Item No. **Report of the Interim Director of Planning, Regeneration & Public Realm**

Address: 1372 UXBRIDGE ROAD HILLINGDON

Development: Variation of Condition 2 (approved plans) of planning permission ref. 5625/APP/2019/917 dated 10-05-2019 'Three storey building for use as 3 x studio flats and 2 x 1-bed self contained flats, installation of 2 x vehicular crossovers and demolition of existing two storey building' to enlarge two studio flats.

LBH Ref Nos: 5625/APP/2023/937

SCALE 1:50 @A1	DRAWING No.	REV.
DATE MAR '19		
DRAWN LK	4971-9	C

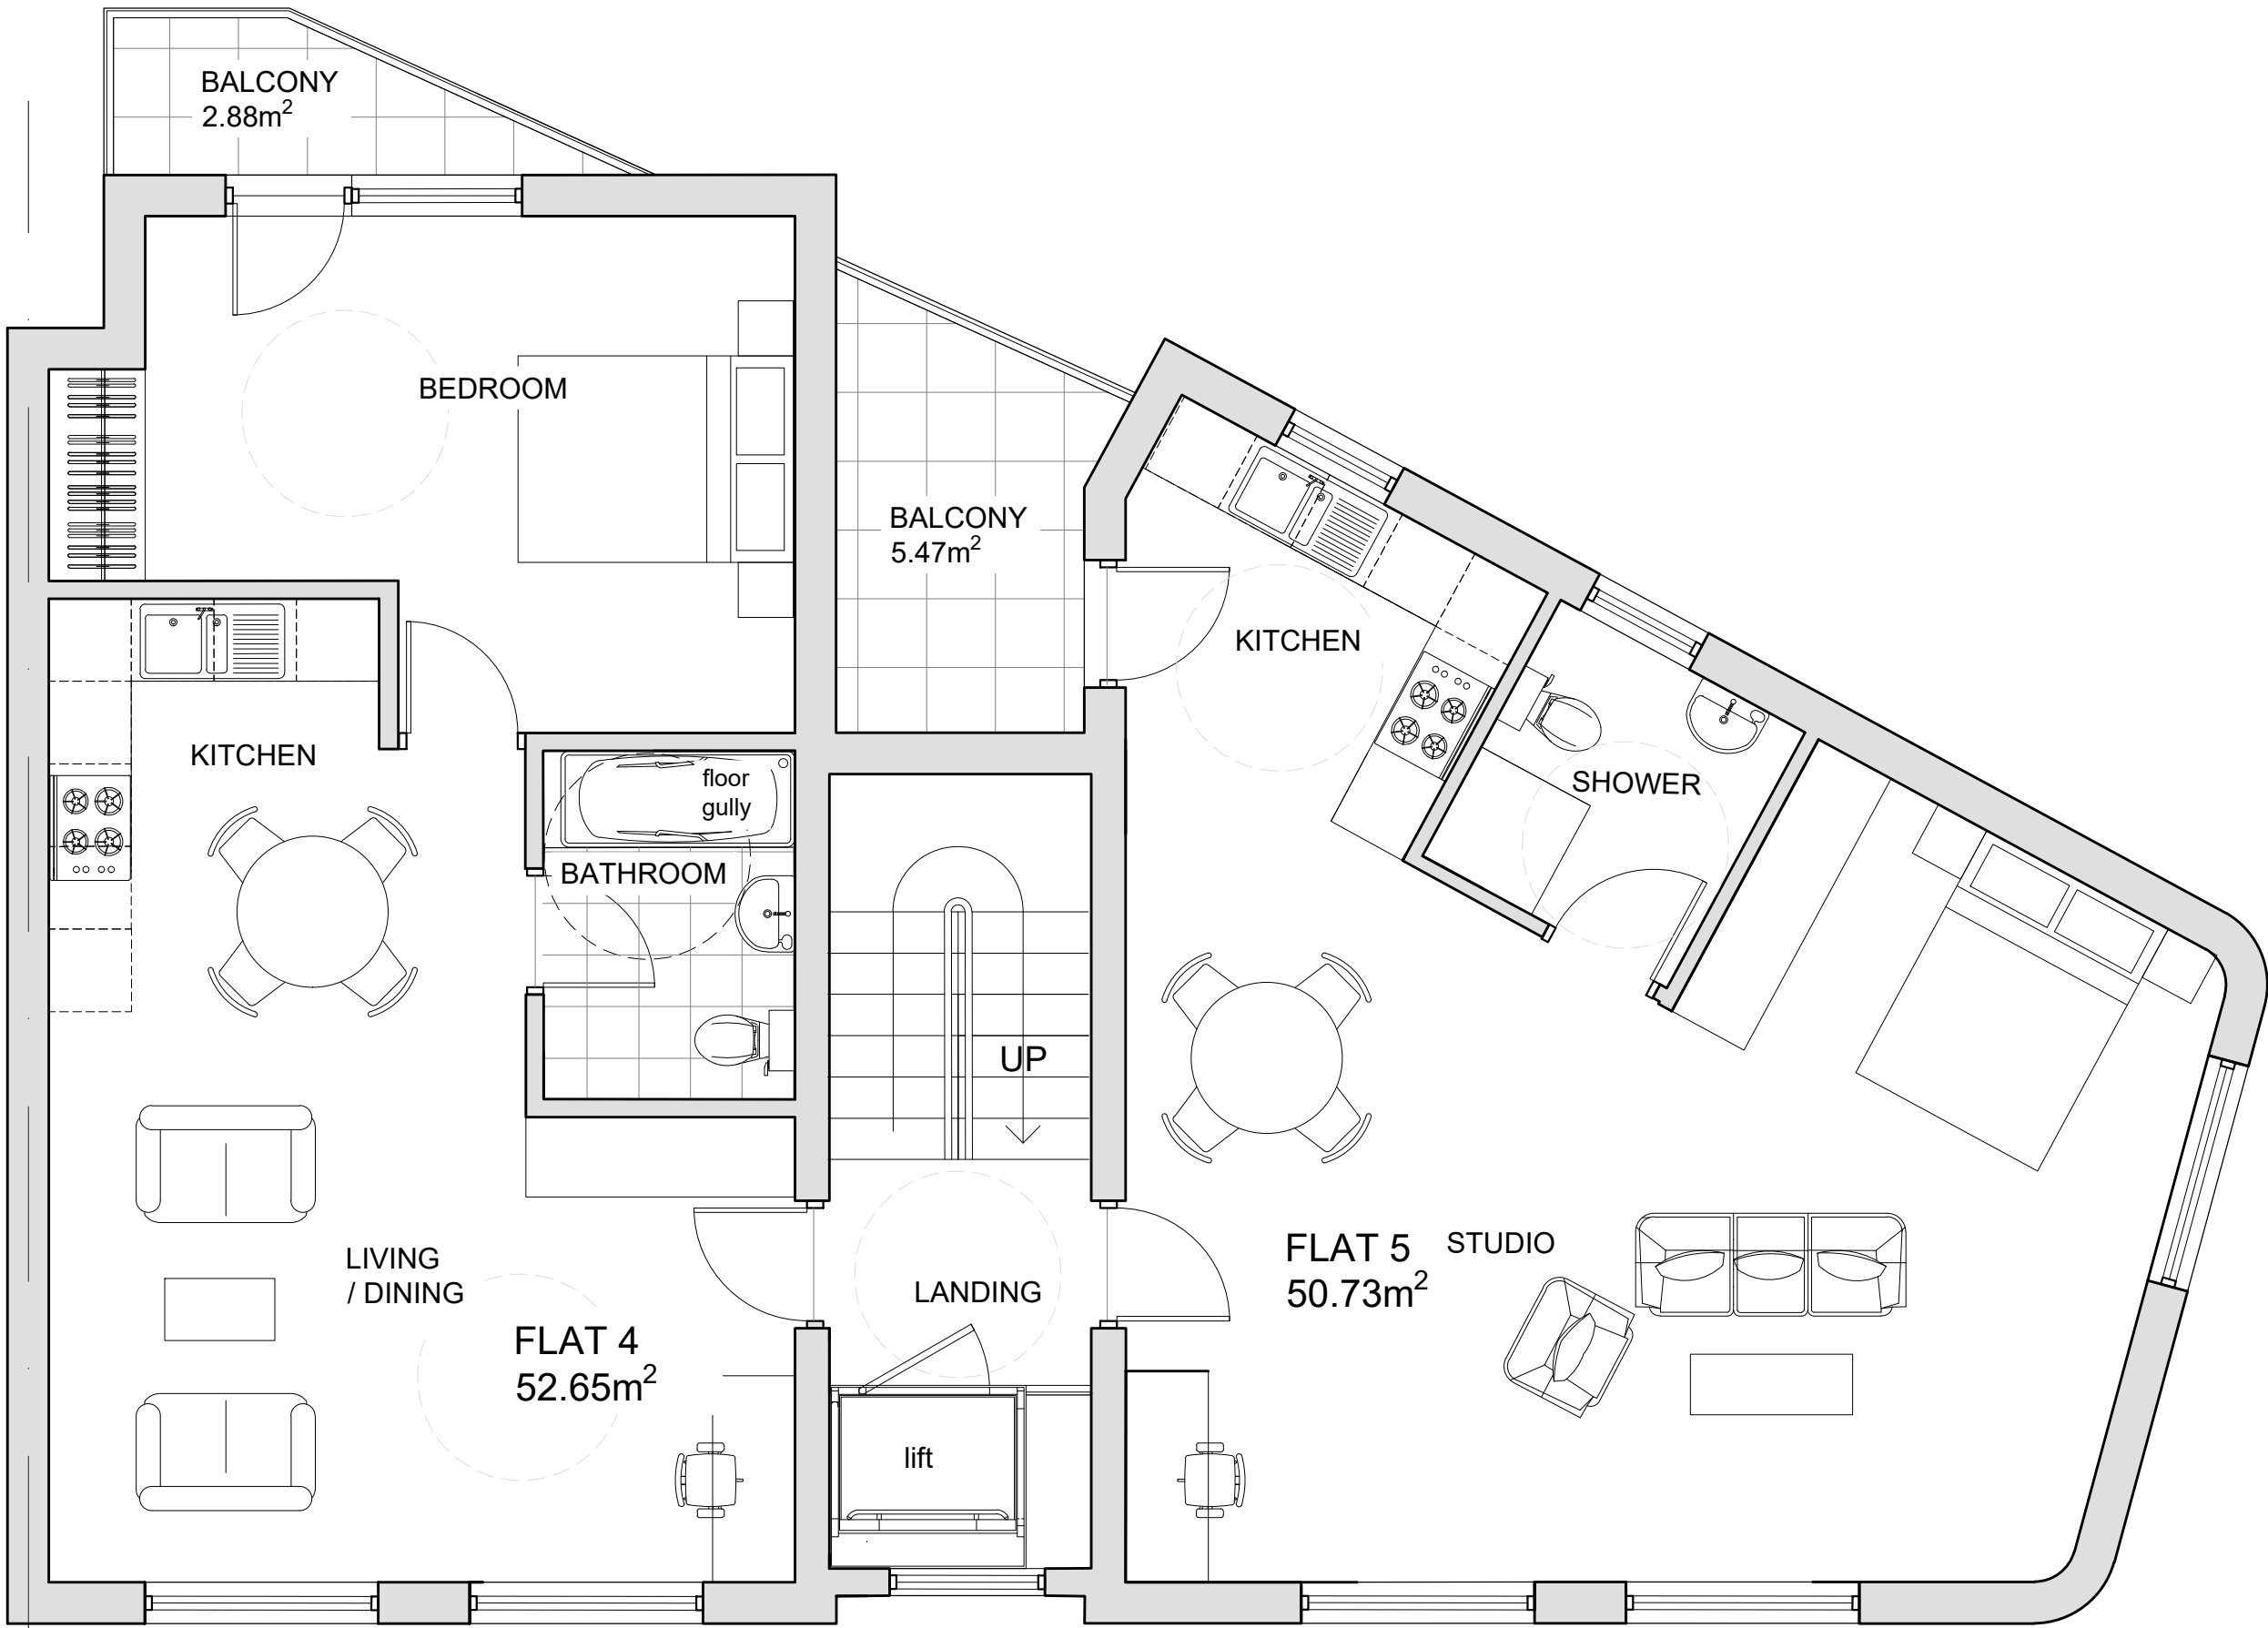
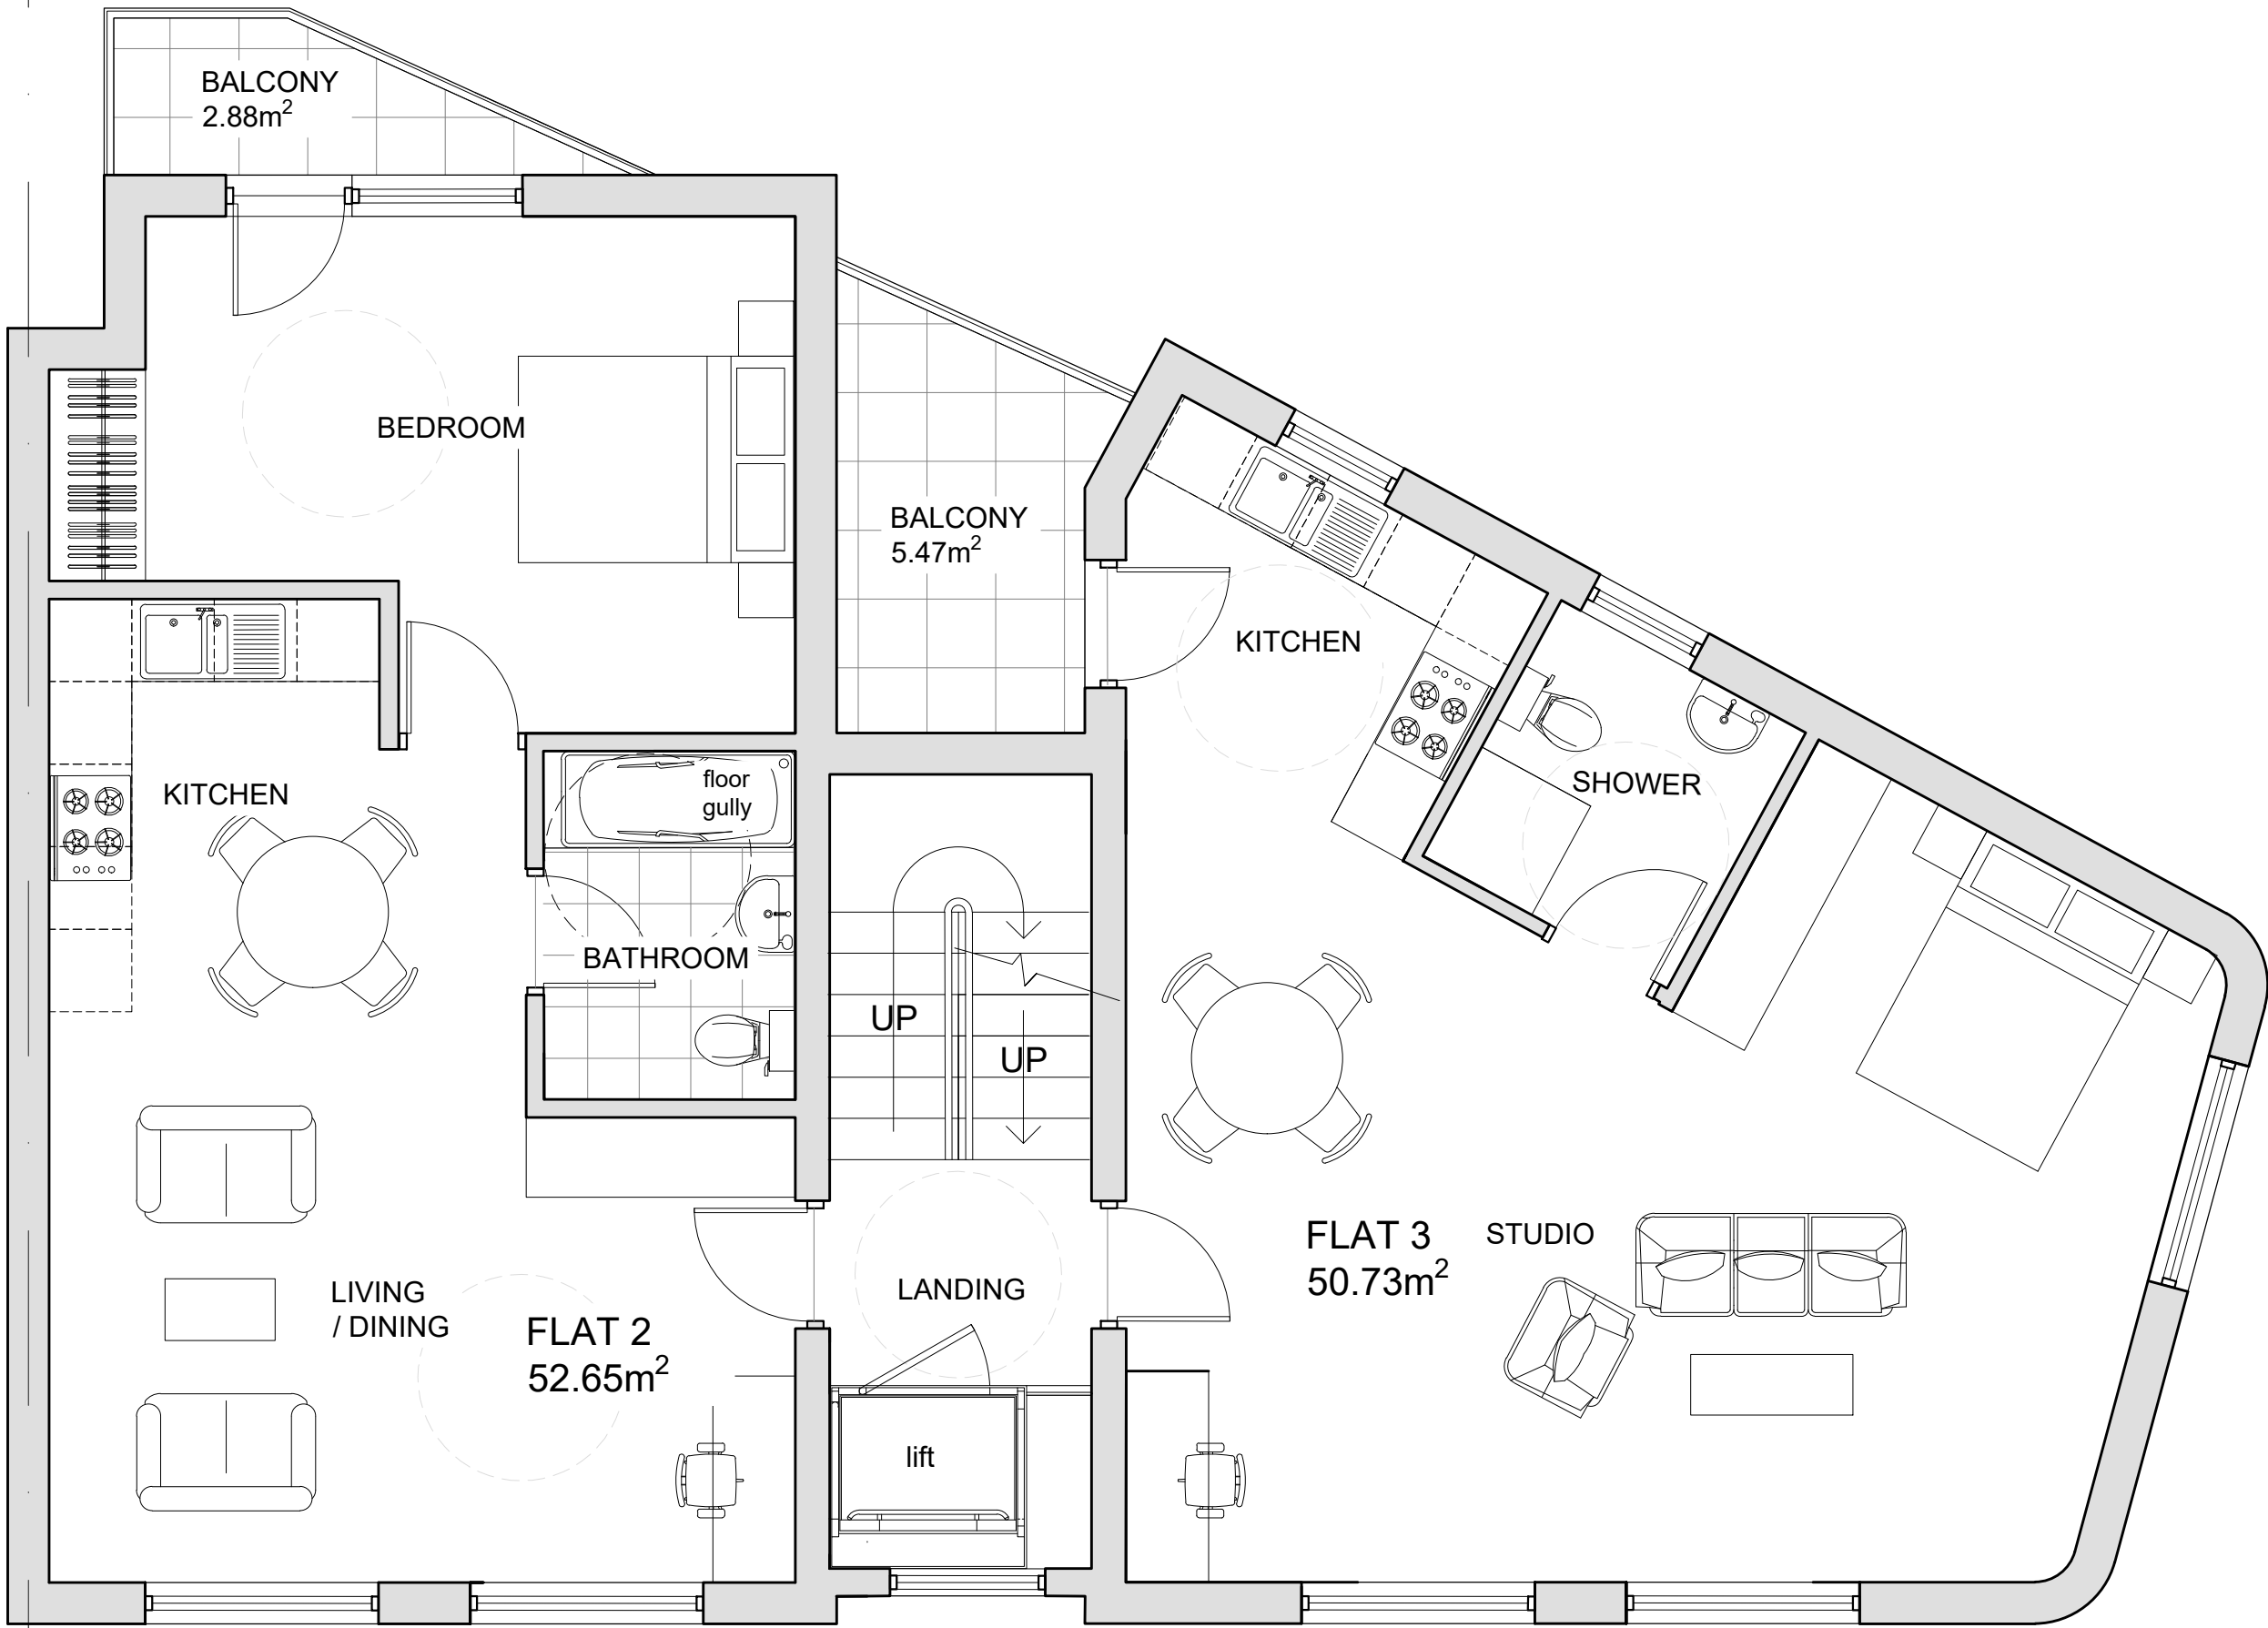
There are a diverse range of styles, designs and materials in the make up of the existing properties within the street scene. The application site is in a particularly prominent and visible location at the end of the a row of properties of similar scale and two-storeys on the corner of Uxbridge Road with Hewens Avenue. The submitted streetscene indicates the approved but not implemented three storey building at number 1380 Uxbridge Road under application reference 71035/APP/2016/4048 for the erection of a three storey building to provide 5 x 2-bed self-contained flats with associated parking, cycle and waste storage. The existing building is not considered to be of any architectural merit and its loss and replacement with a 3 storey building of similar scale to that approved at the nearby site at 1380 is considered acceptable. The proposed amended building would increase the overall bulk of the building towards Hewens Road. The visual impact would appear acceptable from Uxbridge Road, but the additional massing towards Hewens Road, with the additional massing making the upper floors appear top heavy and would be an incongruous alteration to the approved building, of particular concern in this prominent corner location. The undercroft as extended would be a dark and uninviting space, detrimental to the street scene.

The proposal, by reason of its forward projection towards Hewens Road and the increase in the undercroft, in close proximity to the site boundaries, would result in a cramped and incongruous form of development which would detract from the character and appearance of the surrounding area and the visual amenities of the street scene. The proposal is therefore contrary to Policy BE1 of the Hillingdon Local Plan: Part One - Strategic Policies (November 2012), Policies DMHB 11, DMHD 12 and DMHD 1 of the Hillingdon Local Plan Part Two - Development Management Policies (2020).

The original approval included balcony provision for all flats. This provision, given the proximity to the nearby public park, was considered acceptable. In this case, the proposal would result in a re-arrangement of balconies with the 2 enlarged studios being provided with inverted balconies. All units would achieve a satisfactory outdoor amenity space provision.
